TITLE	RESPONSE TO SUBMISSIONS	
ADDRESS	20 Kelso Crescent, Moorebank.	
REFERENCE	SSD-58978472	
CONSULTANT INPUTS	The following consultants are highlighted throughout:	WTP
		Genesis
		Nettleontribe
		Geoscapes
		Acoustic Works
		TTW
		Getex

ENCLOSURES
Report/ Document
Appendix D1 - RTS Response Matrix (this document)
Appendix D2 - Section 88B Instrument for Lot Amalgamation
Appendix D3 - Revised Architectural Drawings
Appendix D4 - Updated Landscape Package
Appendix D5 - Traffic Assessment Addendum
Appendix D6 - Flood Assessment Addendum
Appendix D7 - Flood Emergency Response Plan
Appendix D8 - Noise Impact Assessment Addendum

Drawing Number: **12865_DA-112** Issue: **[G]**

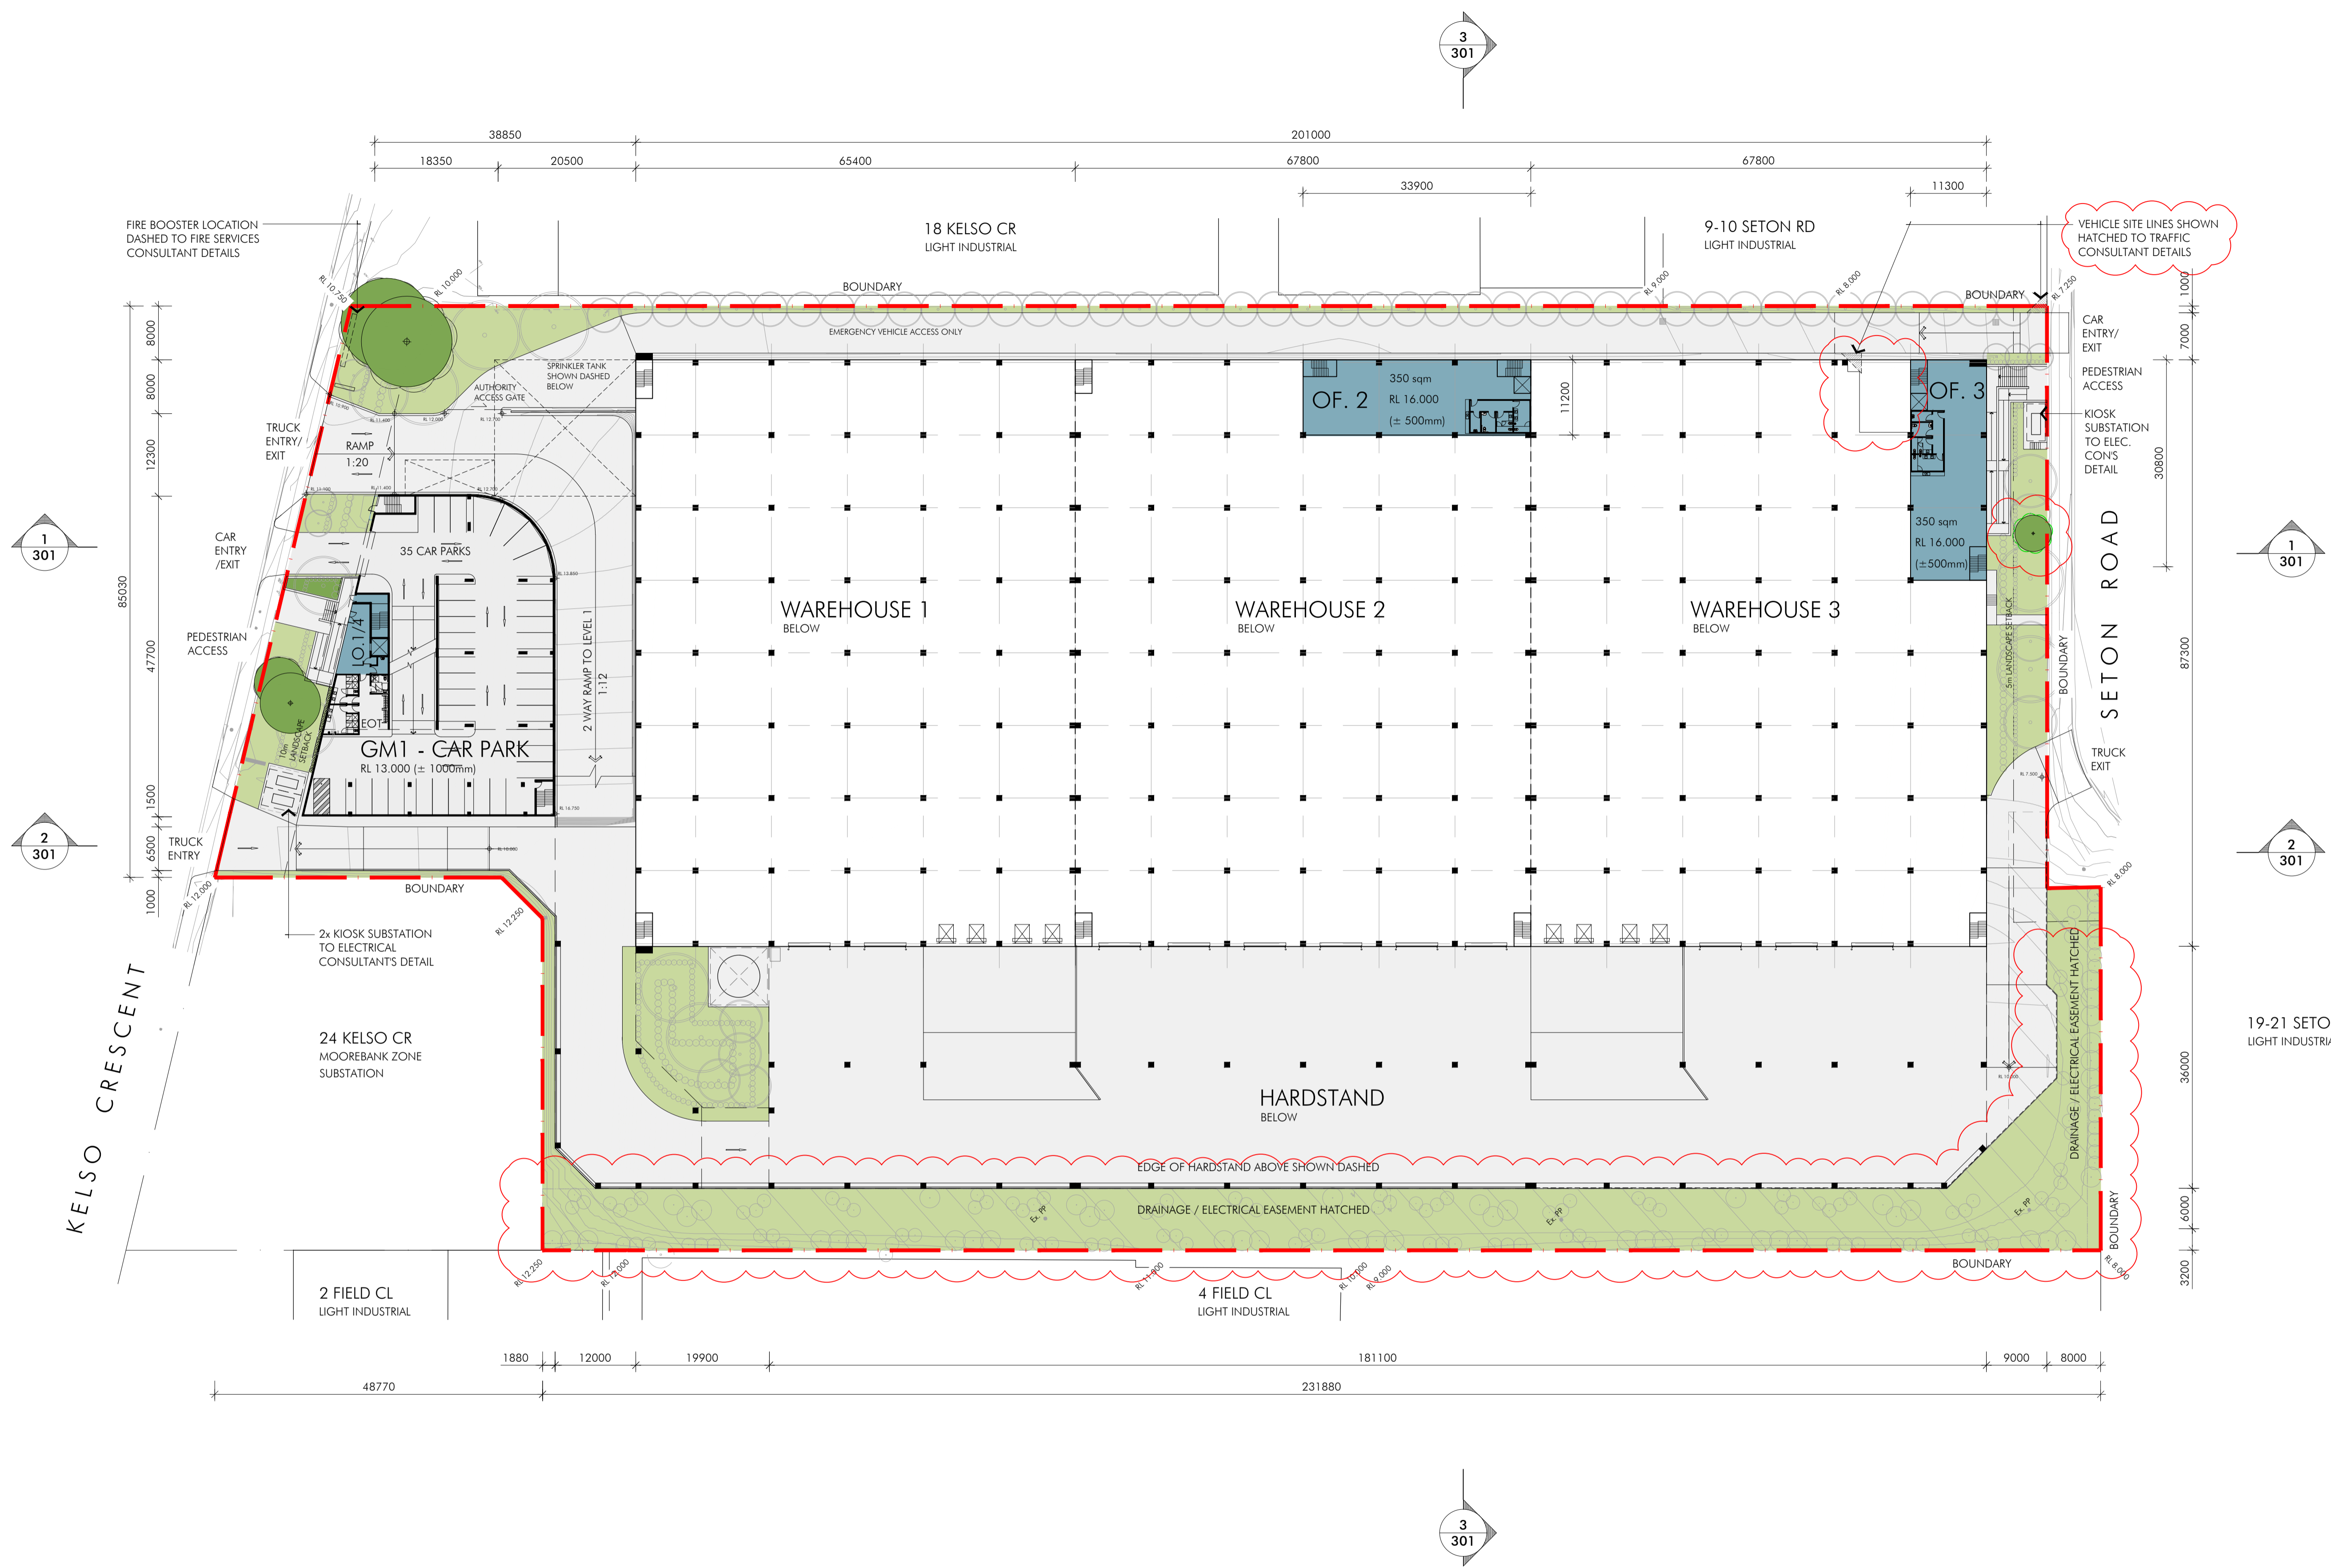
demonstrating successful mitigation pursuant to the condition of the Development Consent.
Signage	The signage proposed as part of this application seems excessive. The DCP (Part 1, Section 26 'Outdoor Advertising and Signage') limits free standing signs to a maximum 5m in height. Council requests the proposal is amended to comply with Council's DCP.		WTP Nettletontribe	With reference to the revised Architectural Drawings enclosed at Appendix D3 , refer to DA-902[D] for details of the revised signage. The previous 10.04m Estate Entry Sign has been reduced to a 5m combined Estate Entry/ Truck Entry and Exit sign, which complies with the relevant provisions of the Liverpool Development Control Plan 2008 (LDCP 2008).
Driveway over Easement and Easement Relinquishment	Endeavour Energy must be consulted and support the relocation of the easement.		Nettletontribe	With reference to the revised Architectural Drawings enclosed at Appendix D3 , refer to DA-112[G] and DA-113[G] . This confirms that there will be no new road or structure on the easement.

Drawing Title:
Landscape Plan
 DWG No:
SSD-01

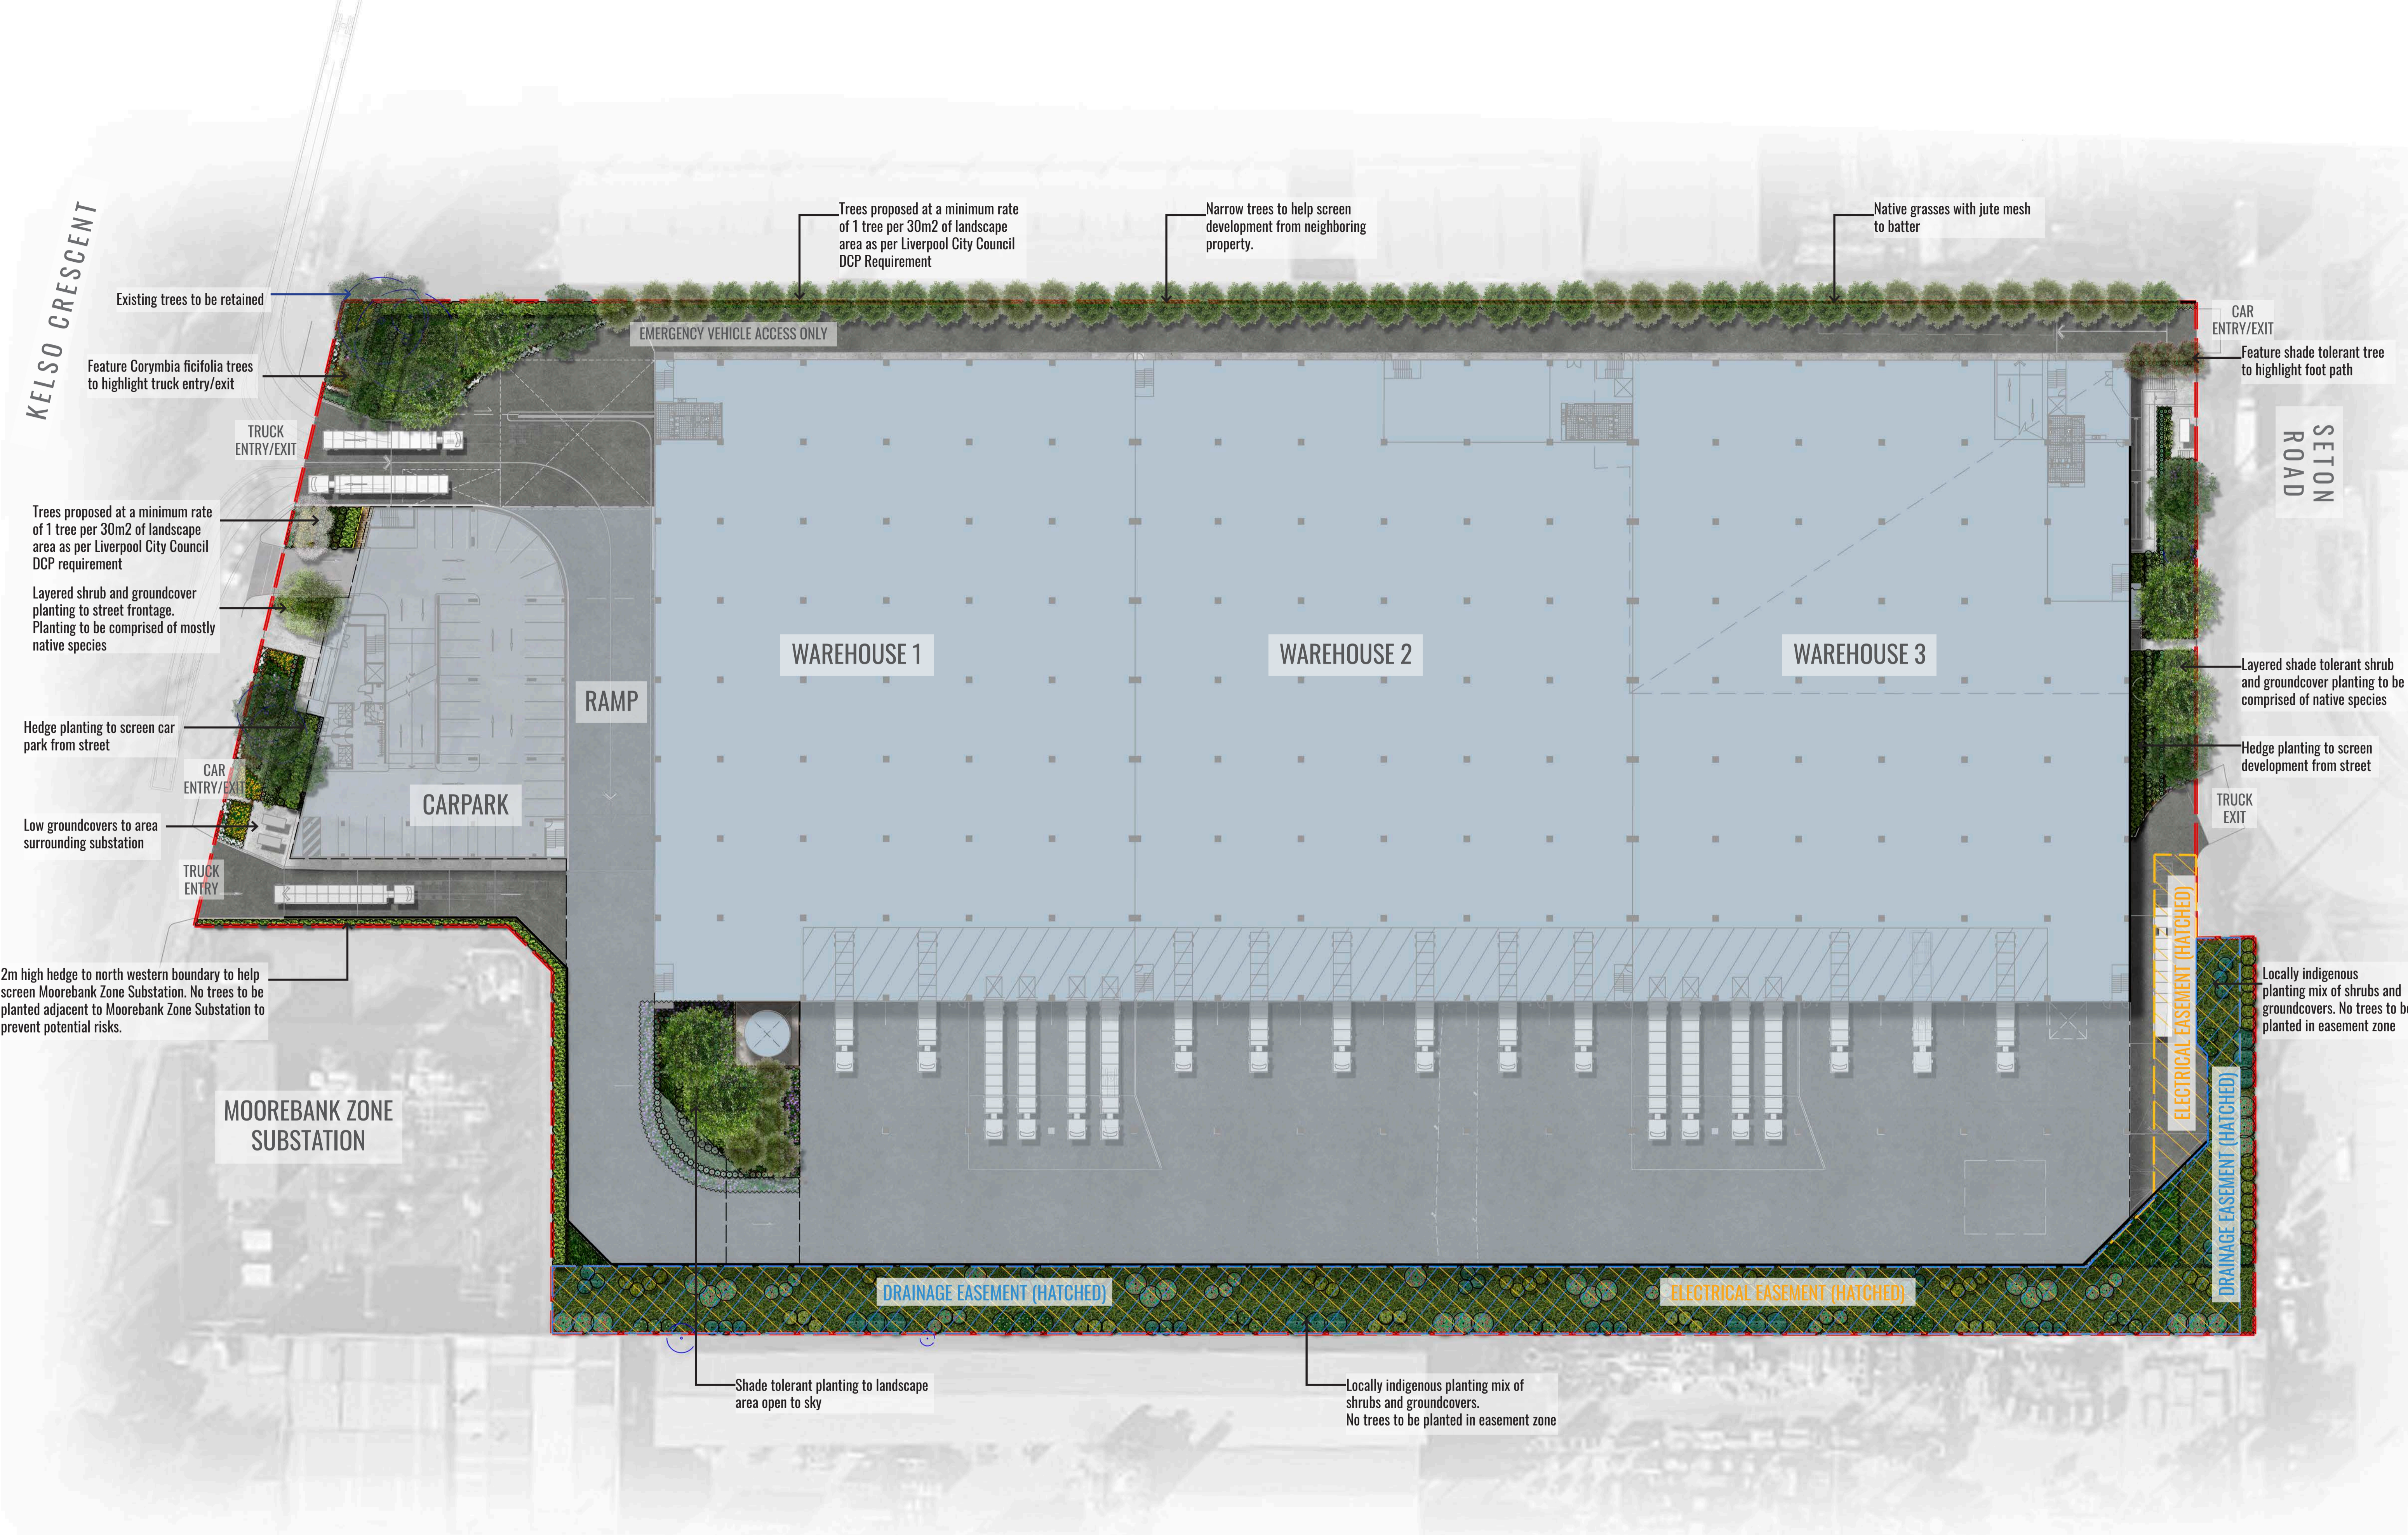
Urban Design Considerations				
Landscaping Setbacks	Seton Road setback interpreted as a primary setback and should be increased to 10m.		WTP	The Seton Road setback ranges from 9m to 16.8m when measuring the new building line to the property boundary, which is fully landscaped except for the entry/ egress points, and accounts for the stepped form of the site's southern (rear) boundary.
Built Form and Street Interface	Excessive stairs and ramps are overtaking space in the setback that could be dedicated to landscaping and deep soil. The ground level of the southern elevation on Seton Road is mostly blank wall and not an acceptable street interface. Car parking on a street frontage is a poor urban design and amenity outcome. Council staff request clarification of how many levels of car parking are visible from the street interface, and drawings should be updated accordingly to resolve any inconsistencies or missing details.		Nettletontribe	Kelso Crescent The proposed building on Kelso Crescent integrates an office and car park. Two levels of car park are visible above the natural ground level. The facade conceals these areas with varying materials, creating a cohesive visual identity. Strategically placed cladding and green elements further enhance the building's appearance behind the landscape setback of 10m from the Kelso Crescent Street front.
